**Consultation Response from KC,  
Highways Development Management**

**2020/90614 Morrisons, Station Street, Meltham, Holmfirth, HD9 5QR**

**Erection of extensions to existing store**

<b>Date Responded:</b> 07/05/2020	<b>Responding Officer:</b> Ryan Kinder	<b>Responding Ref:</b> K3-14/43
--------------------------------------	---	------------------------------------

EXISTING PARKING

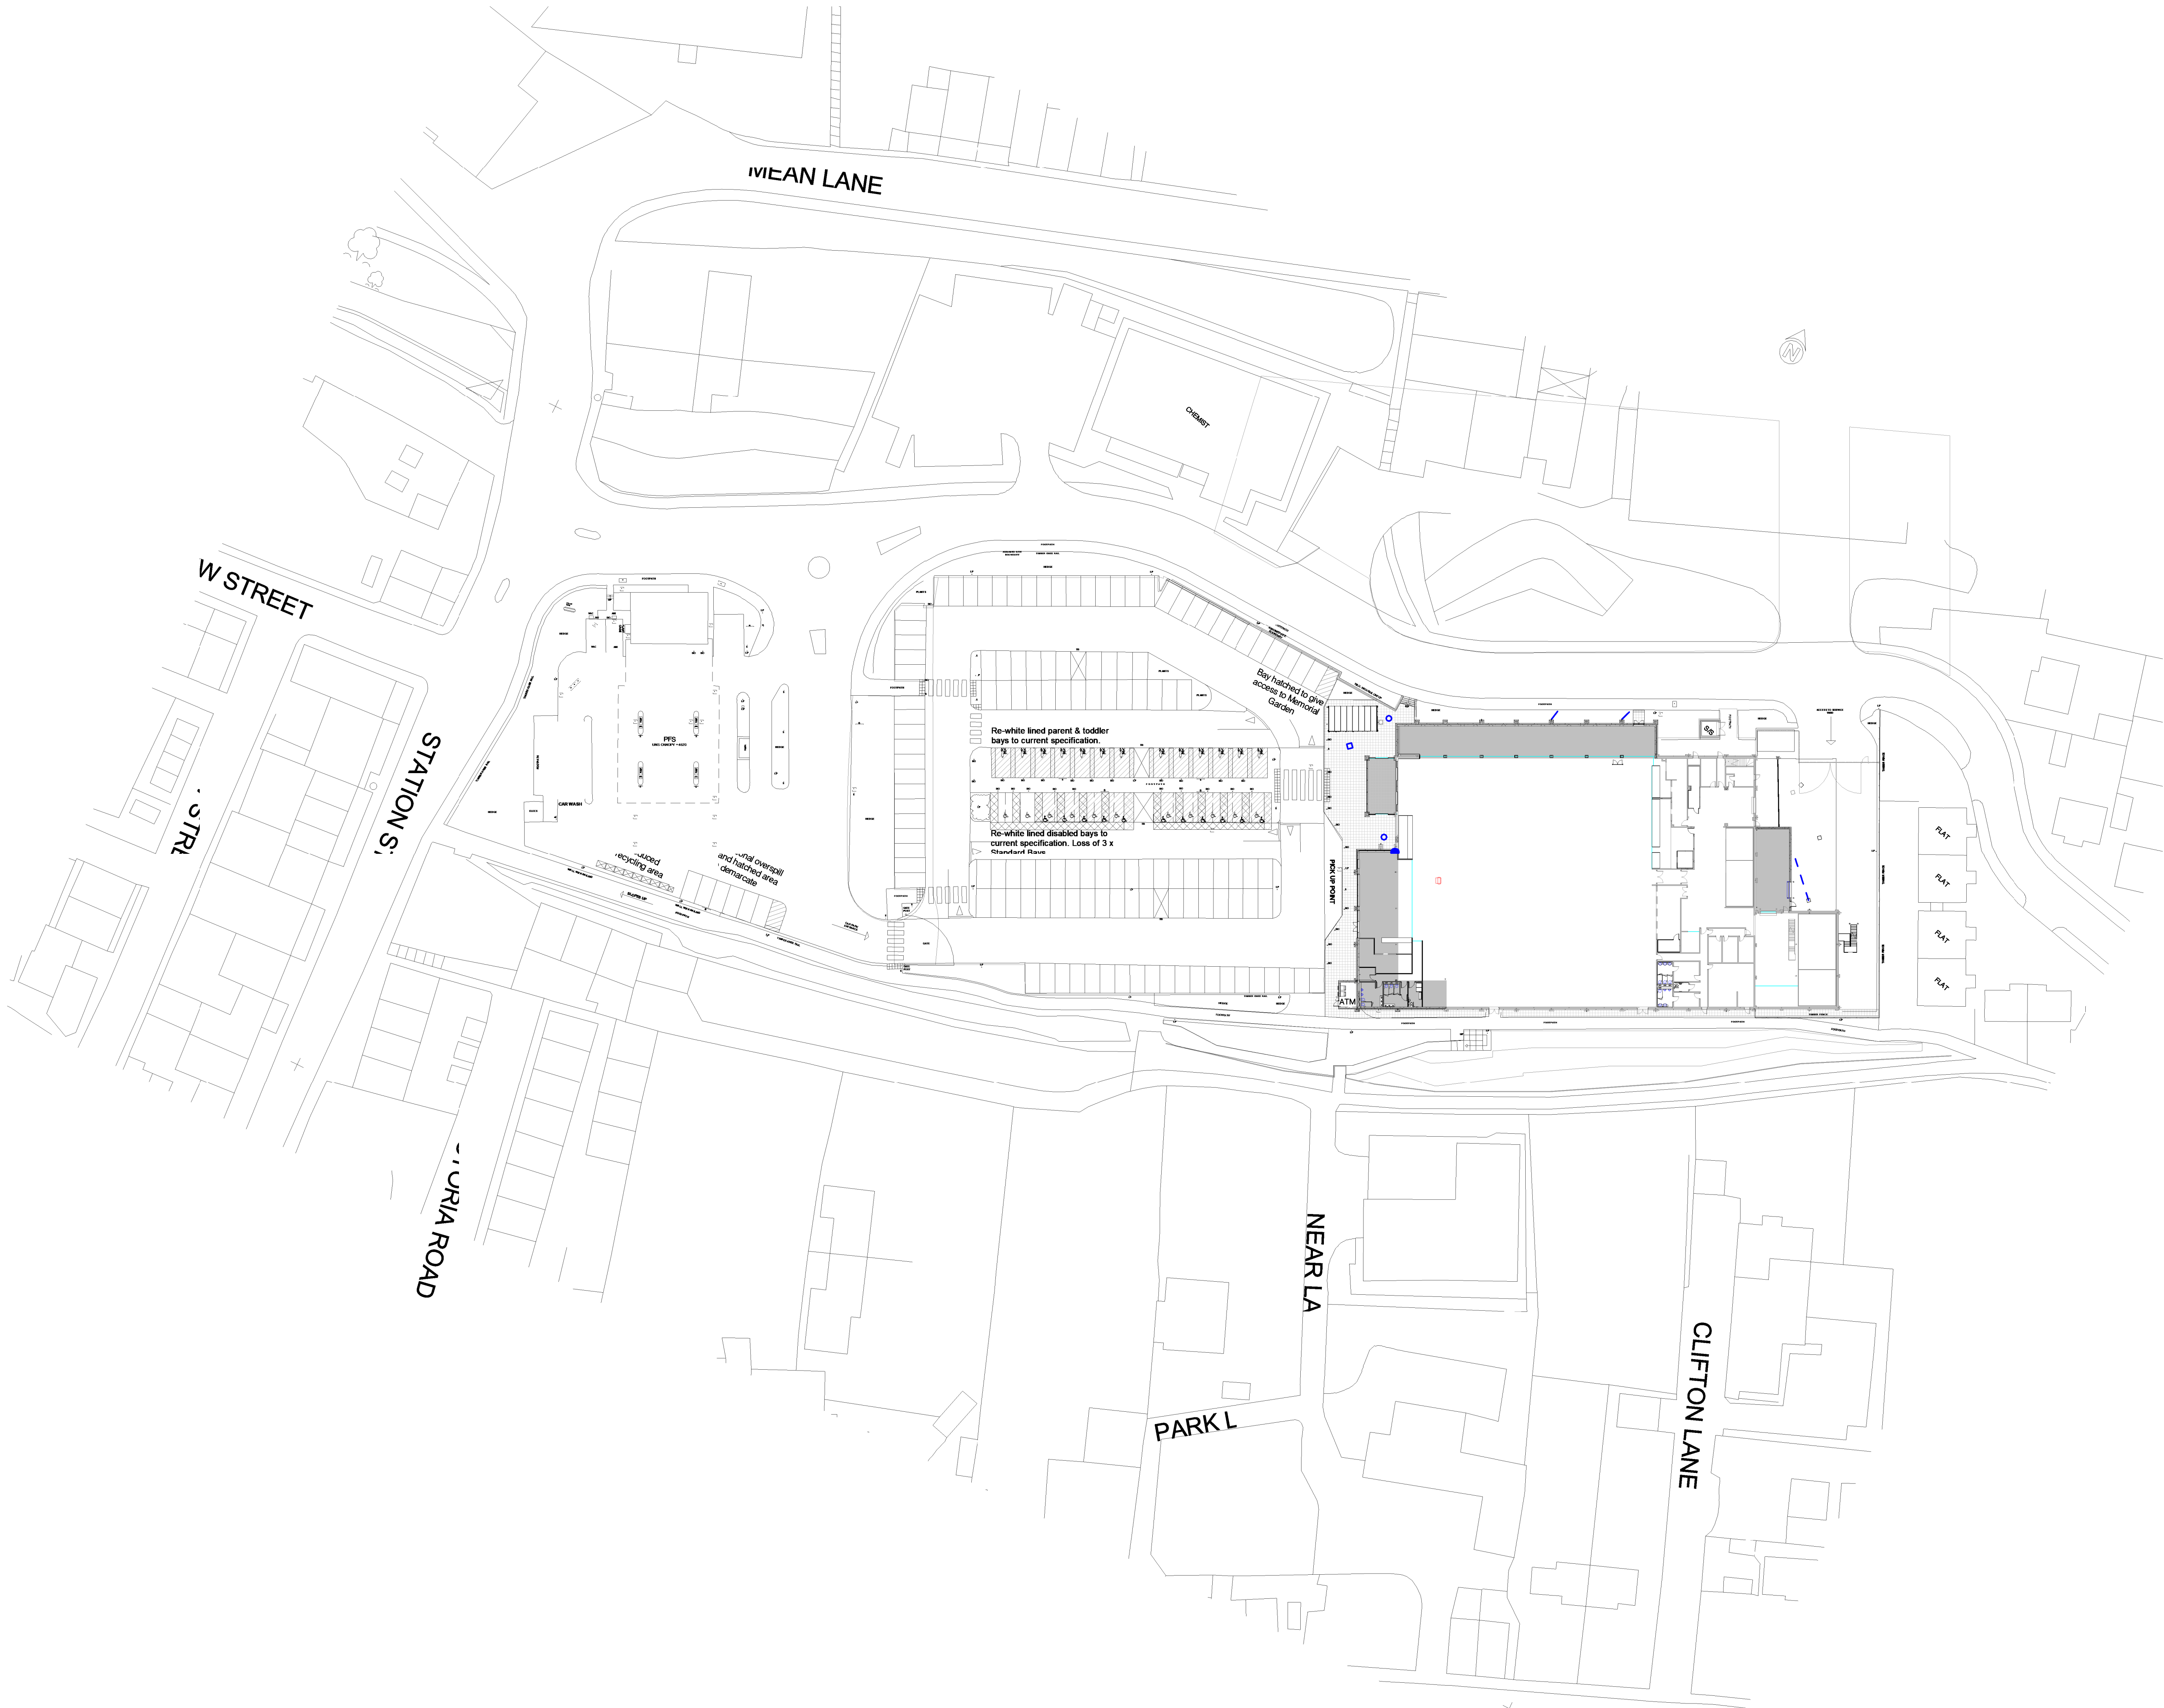
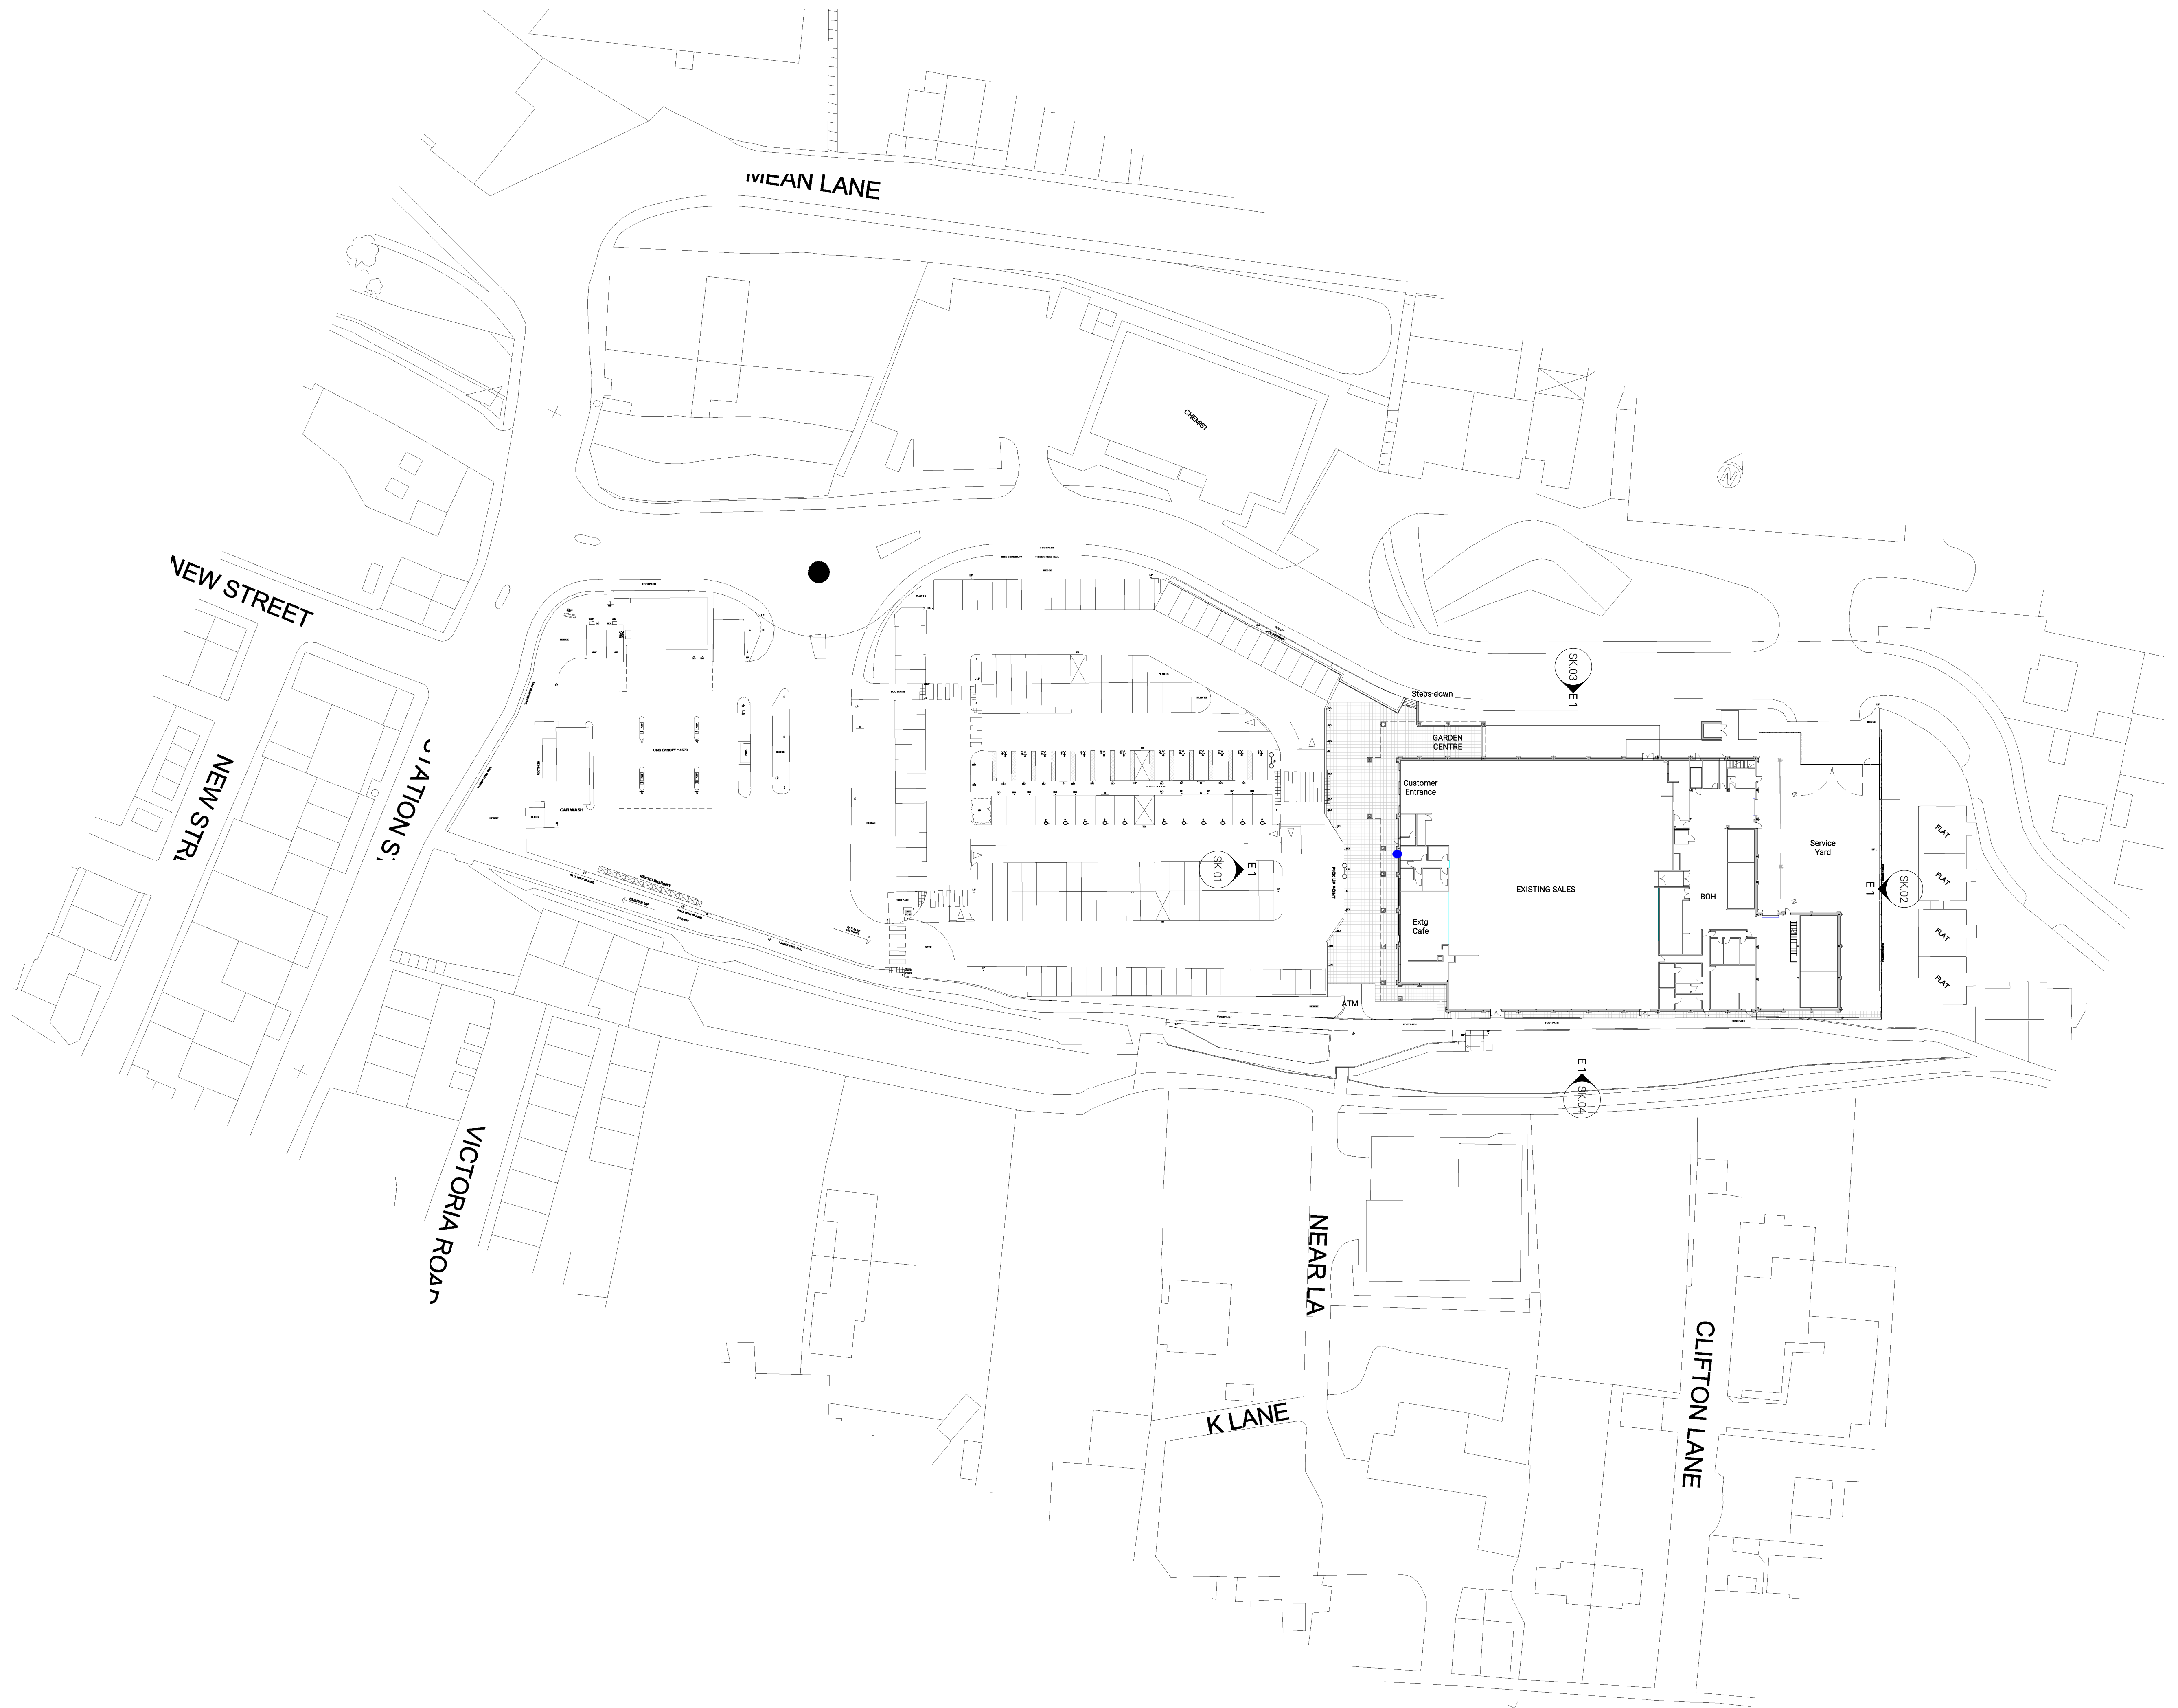
The parking provision for the proposed development is considered to be acceptable with a slight reconfiguration of the existing car parking arrangement giving an over all loss of 2 spaces in total. Details of a parking accumulation survey have been demonstrated during the peak periods this indicates that the car park was at circa 81% capacity at its peak.
